August 12, 2020

**Subject: ABQ School of Excellence Expansion Traffic Impact Study
NM 556 (Tramway Blvd) at Lomas Blvd. (MP 14.1)
Albuquerque, New Mexico**

This letter is to inform you that the **FINAL** Traffic Impact Study (TIS) for the proposed ABQ School of Excellence Expansion Project west of NM 556 on Lomas Blvd dated June 4, 2020 has been reviewed. See Exhibit A for the conceptual site plan and its proposed access point. The TIS recommendations can be found in Exhibit B. Since the time of this submittal revisions were made to the analysis and an addendum to the recommendations was submitted, see Exhibit C for this letter.

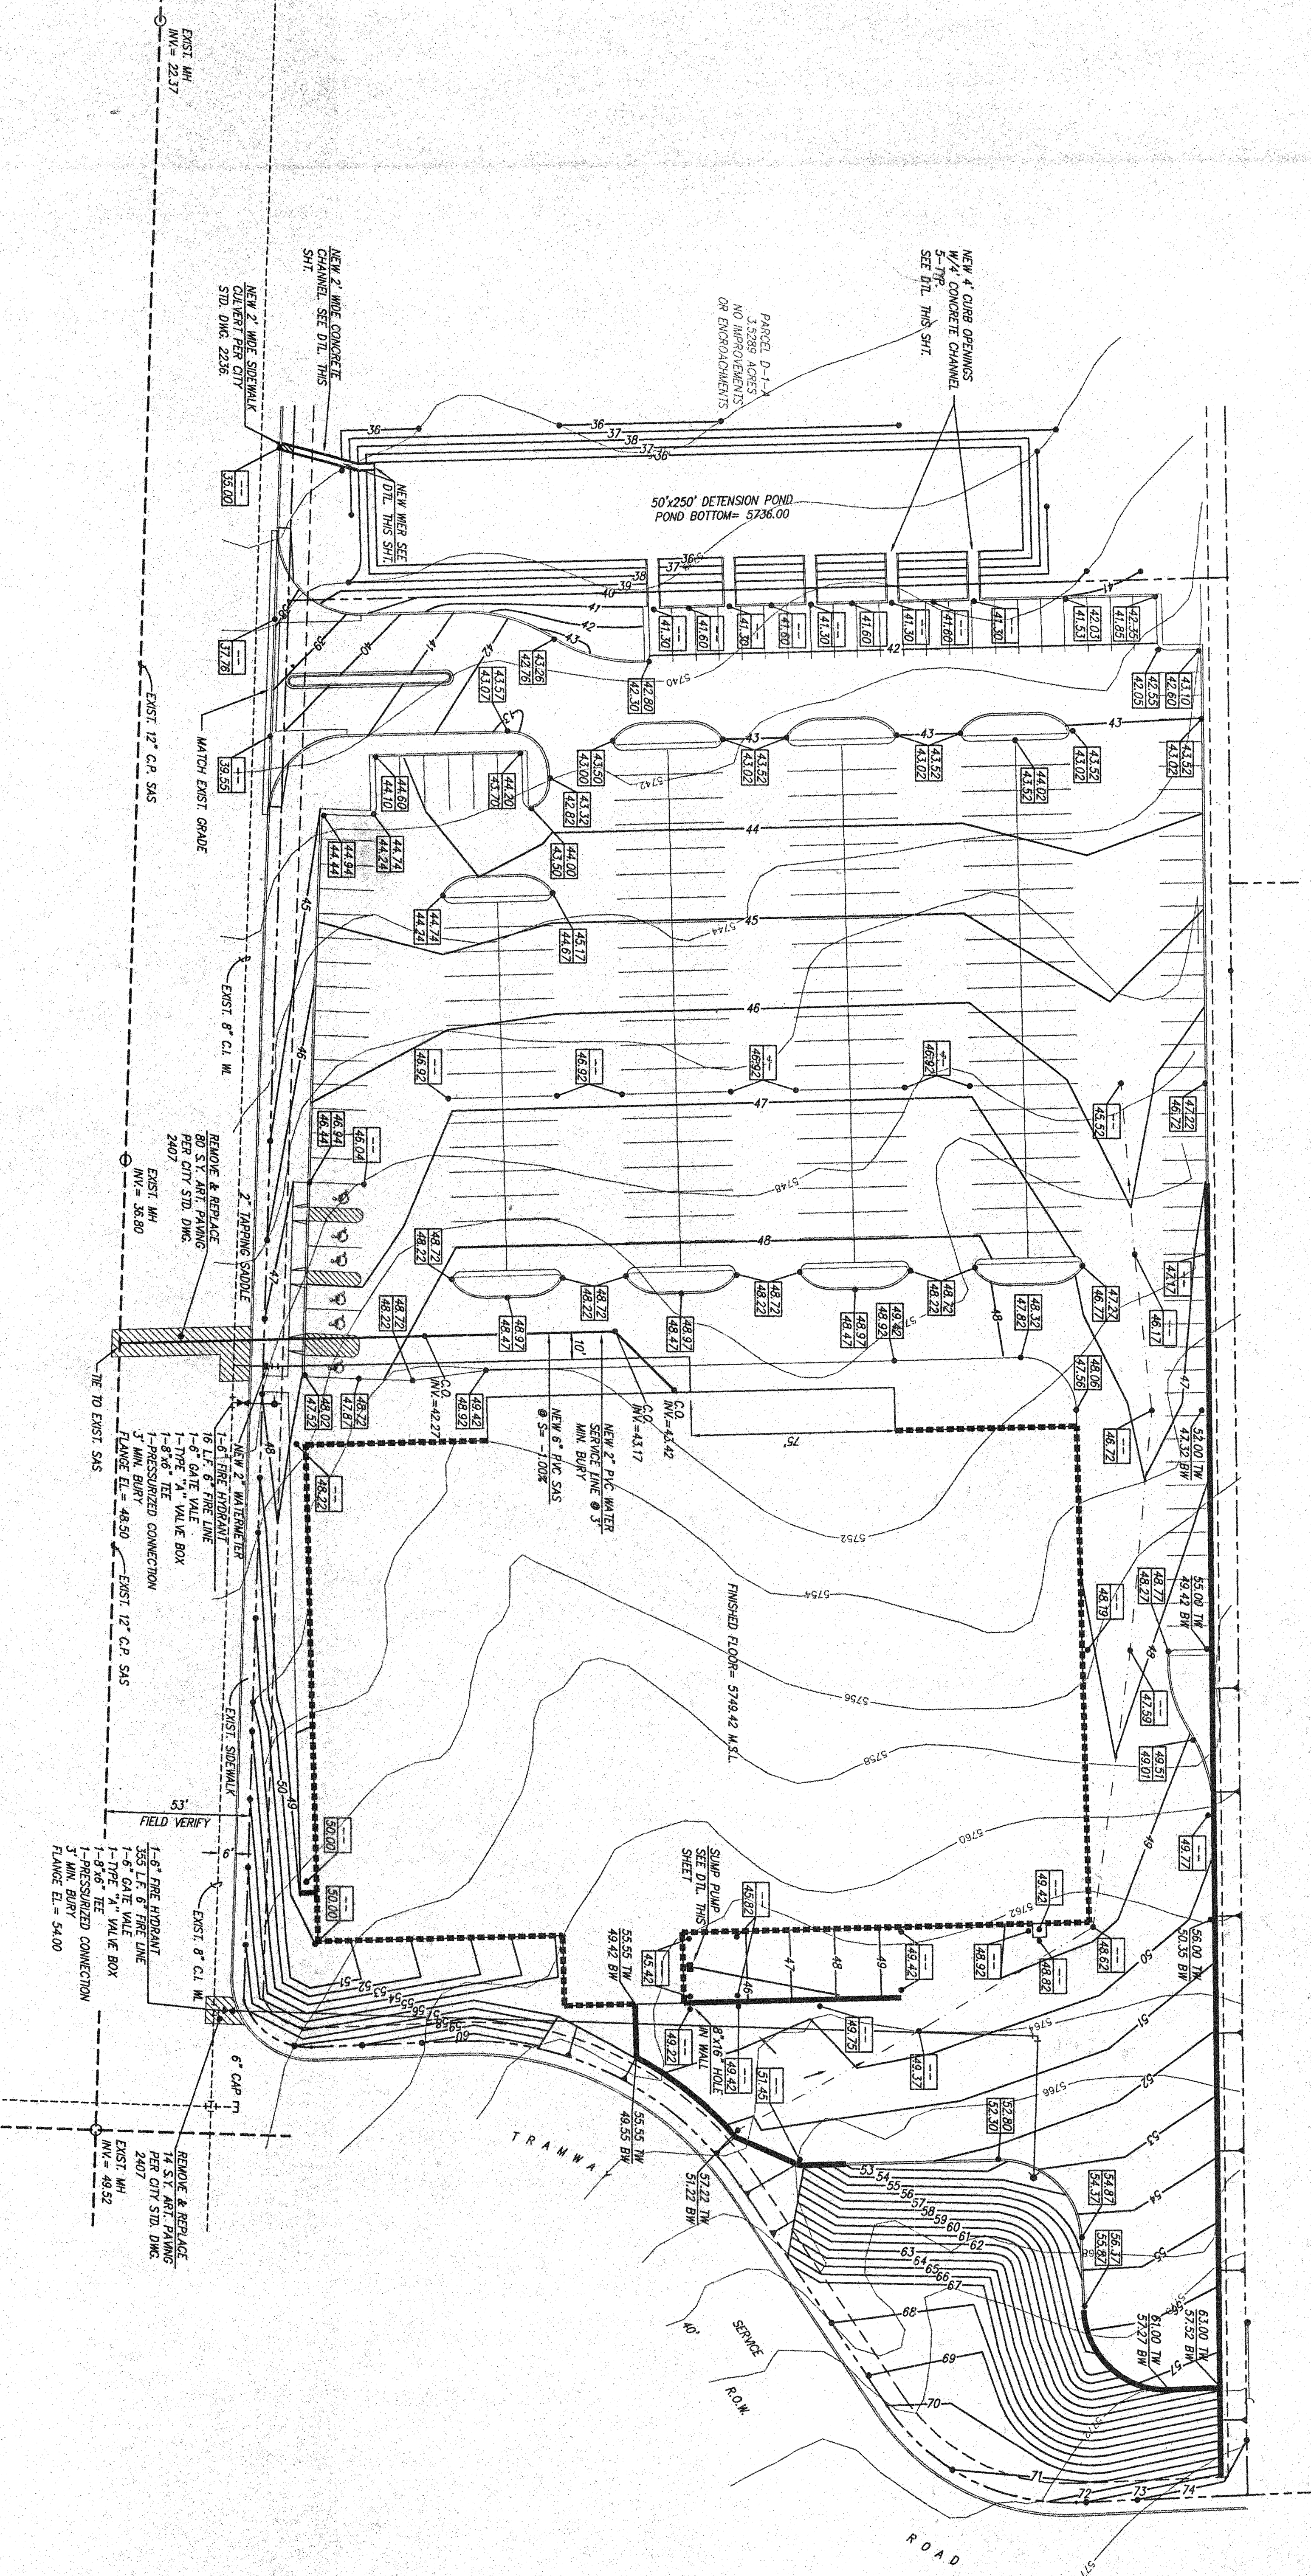
At this time, the NMDOT has no objection to the full access at Driveway "A" on Lomas Blvd. located 850-feet from NM 556. Although Driveway "A" is outside of NMDOT's jurisdiction it does not meet the State Access Management Manual's full access spacing requirements from the signalized intersection of NM 556 and Lomas Blvd. Based on this TIS, NMDOT has the following conditions regarding final concurrence of this development:

1. This development shall maintain staggered start times for middle/high school and elementary school as proposed in the attached email in Exhibit D.
2. This development shall extend the northbound left turn lane at NM 556 and Lomas Blvd to a total length of queue plus deceleration. This equates to 450-foot queue storage, 300-foot deceleration lane, plus 175-foot taper.
3. This development shall extend the southbound right turn lane at NM 556 and Lomas Blvd to a total length of 300-feet plus 175-foot taper. The existing lane configuration including the 5-foot bike lane shall be incorporated into the design.
4. This development shall extend the eastbound left turn lane at NM 556 and Lomas Blvd to a total length of queue plus deceleration. This equates to 230-foot queue storage, 200-foot deceleration lane, plus 125-foot taper.

5. This development shall extend the eastbound through lane at NM 556 and Lomas Blvd along the total length of the median.
6. This development shall extend the right turn deceleration lane on Lomas Blvd at Driveway "A" to prevent excessive queues reaching the signalized intersection of NM 556 and Lomas Blvd.
